Town & Country Planning Act 1990 (as amended)
Town & Country Planning (Development Management Procedure) (England) Order 2015
Application for Planning Permission for Works or Extension to a Dwelling

Development Single storey front/side/rear extension, porch to front, dormer to side to create additional habitable roofspace and landscaping to front to create new car parking spaces

Location 17 Stewards Rise Arundel

17SRPRPRK2018-R01
17 Stewards Rise - Arundel
Proposed Car Parking
Scale 1:200 @ A4 (2018)

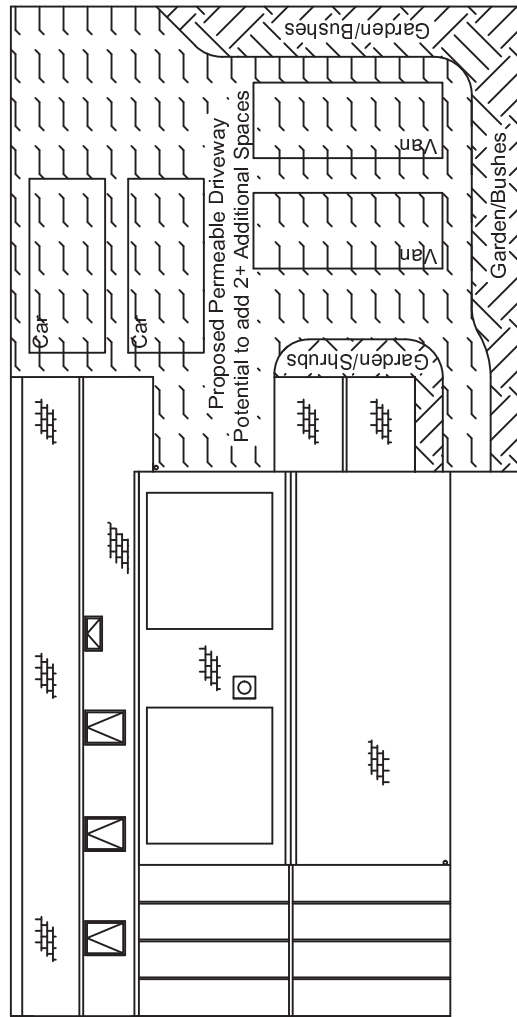
Clarification Required: The plans state you are proposing 2 additional space, however they show 4 additional. Please clarify.
